City of Albuquerque Stormwater Construction Site Inspection Report

ESC File No.	E17E011B	Project Name:	XRANM		
NPDES Id. No.	NMRI004FO	Location:	5800 Jefferson St NE		
6/13/2023	Owner	Contractor			
Operator	Jefferson 25 XRANM QOZB, LLC	Enterprise Builders			
Contact name & title	Jeff Jesionowski	David Lundsten			
e-mail	jeff@amcdevelopment.com	dlundsten@ebnm.com			
Contact Phone #	259-0991	452-7639			
COA Inspector	Chancellor English	Start/End Time:	2pm		
Construction Phase:	infrastructure complete northern lot not stable				
Type of Inspection:	Regular	Storm Event	Post Storm Event >0.25"	311/Complaint	Follow Up
Weather at time of inspection?	Clear		Temperature: ~	80	
Estimated date of last storm 0.25" or greater	5/22/2023

EROSION AND SEDIMENT CONTROL PLAN

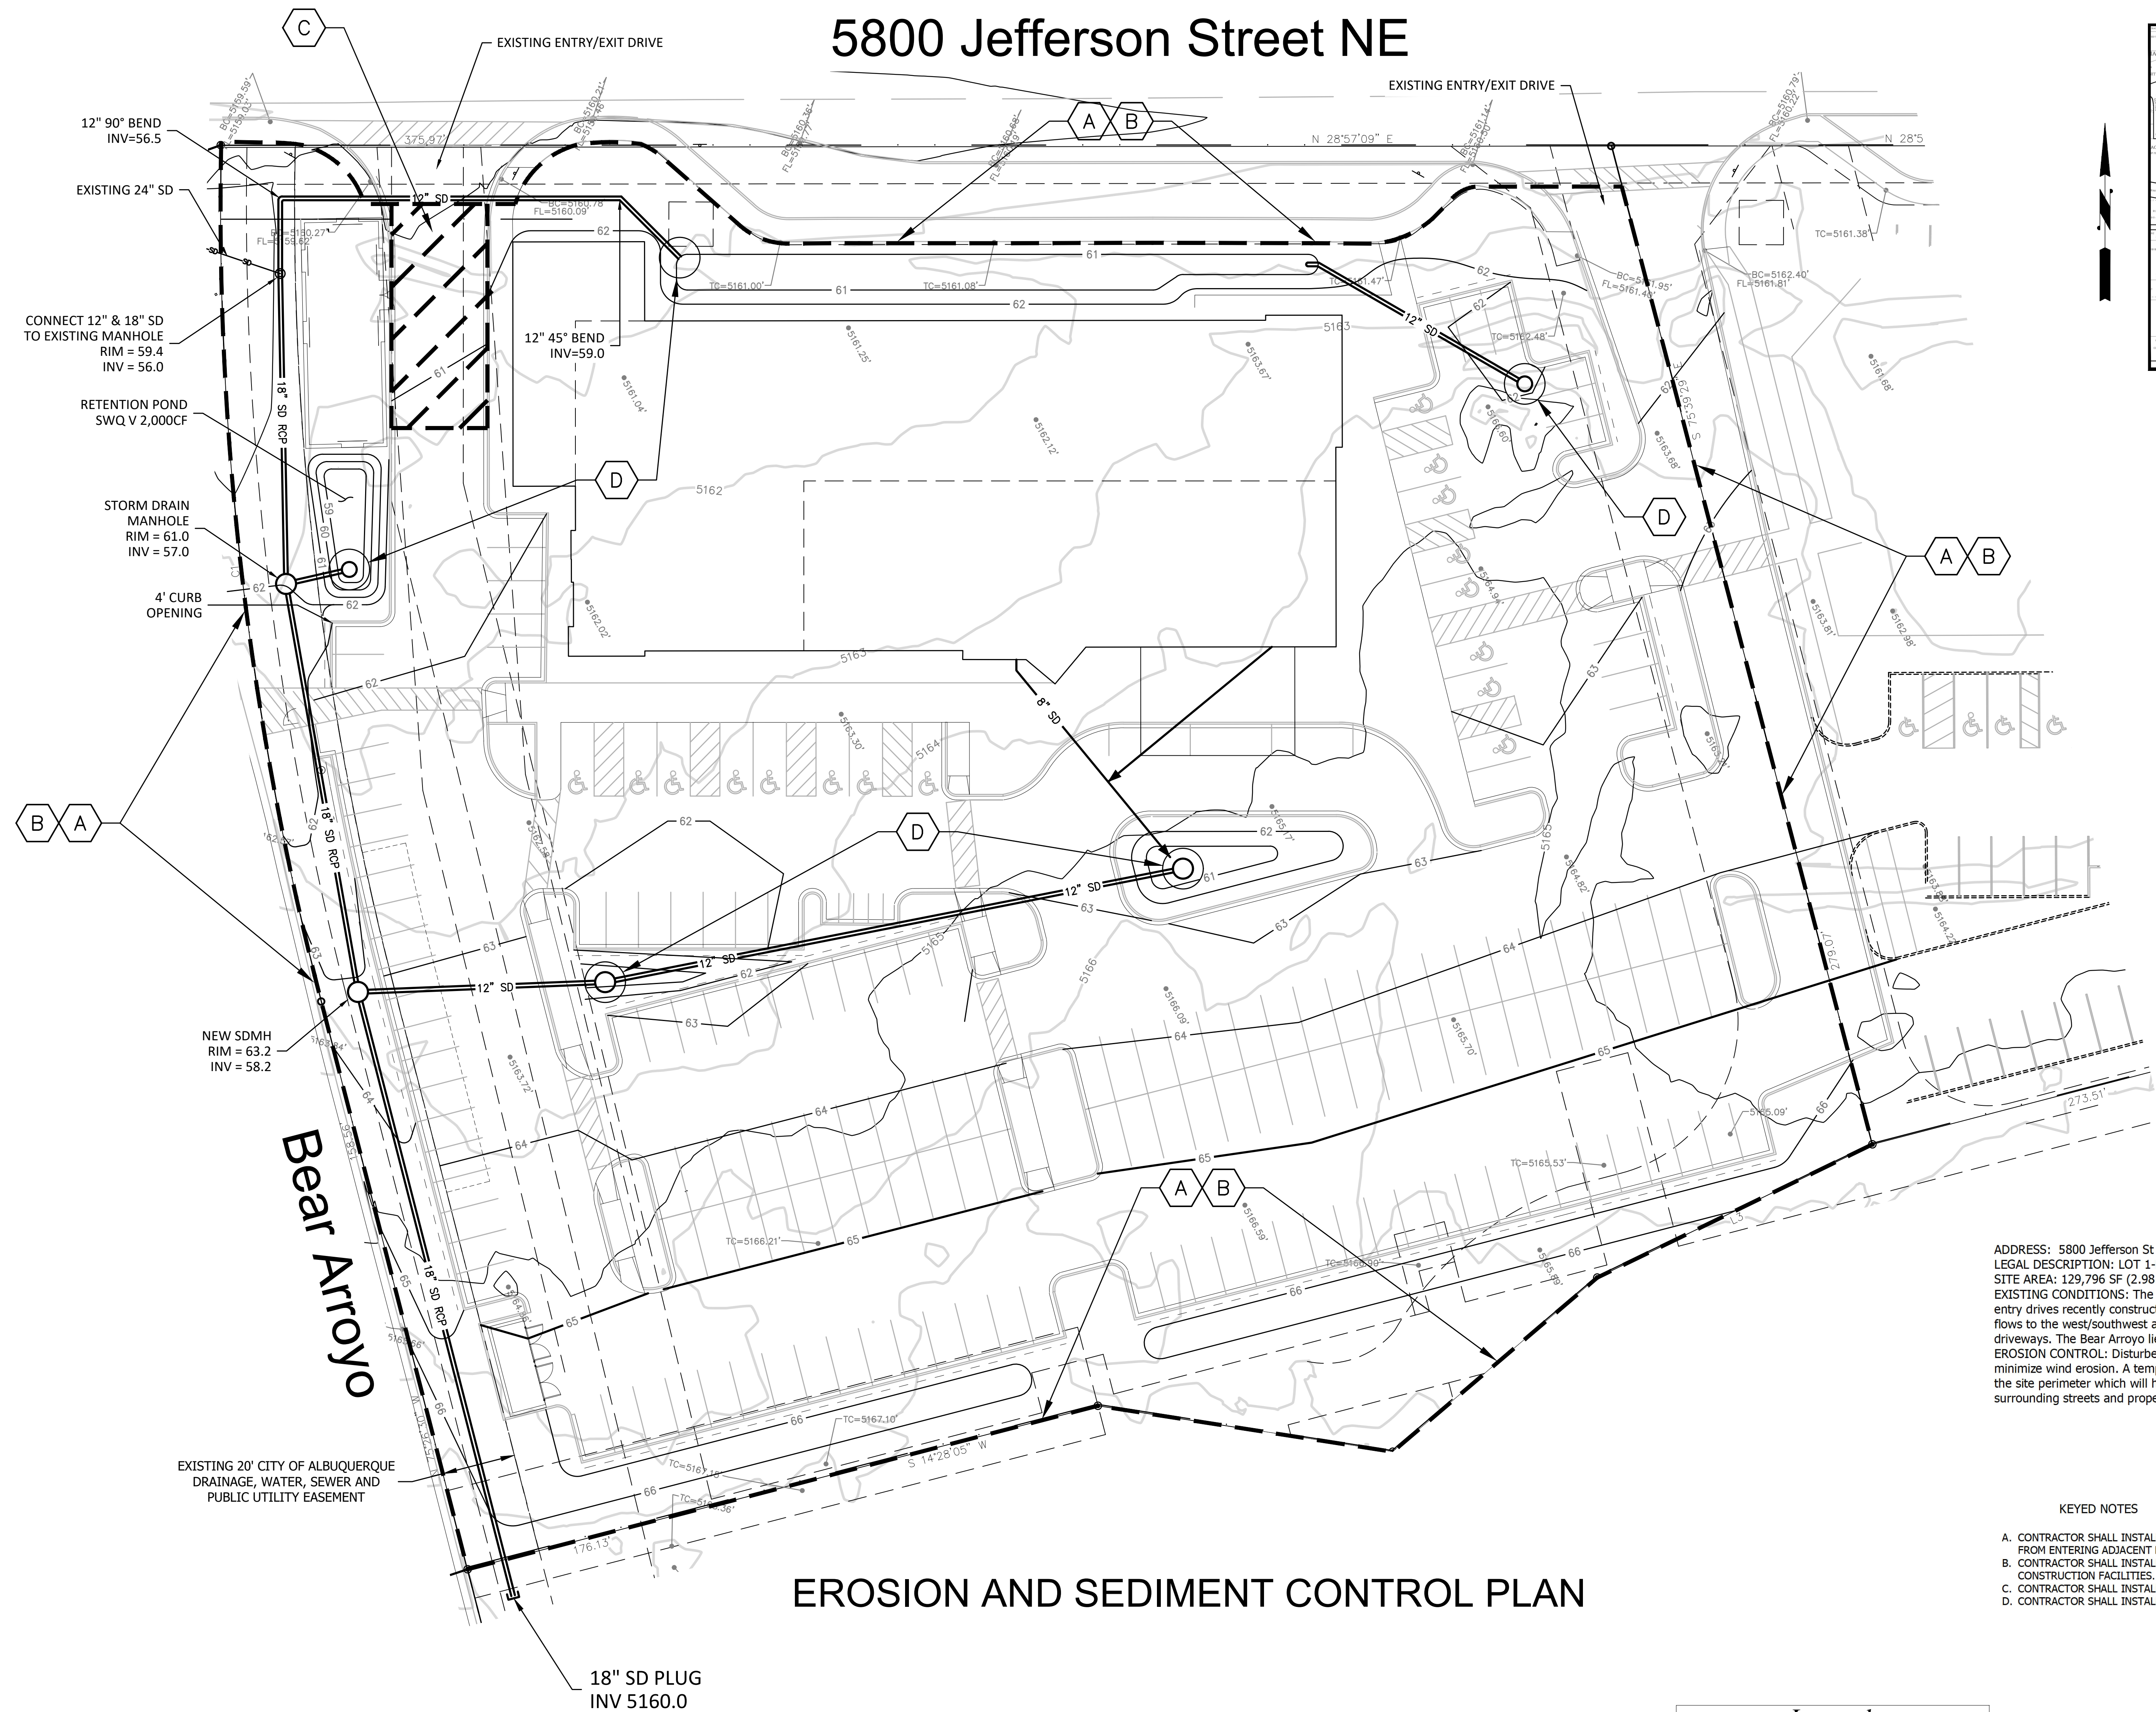
Item Number	Deficiency/ Corrective Action				
1	The lot north of the construction area is not stabilized. The City received an amended ESC plan to include this northern lot on the map which includes instructions to stabilize it using 2" of pit run gravel. Install and place gravel to have no bare soil spots to stabilize the northern lot or provide stabilization that satisfies one of Parts 8.2.1, 8.2.2, or 8.2.3 of the CGP.				
2	In accordance with City Ordinance § 14-5-2-11(C)(1), self-inspections must continue until the site is "determined as stabilized by the city." The property owner/operator is responsible for determining when the "Conditions for Terminating CGP Coverage" per CGP Part 8.2 are satisfied and then for filing their Notice of Termination (NOT) with the EPA. Each operator may terminate CGP coverage only if one or more of the conditions in Part 8.2.1, 8.2.2, or 8.2.3 has occurred. After filing the NOT with the EPA, the property owner is responsible for requesting a Determination of Stabilization from the City.
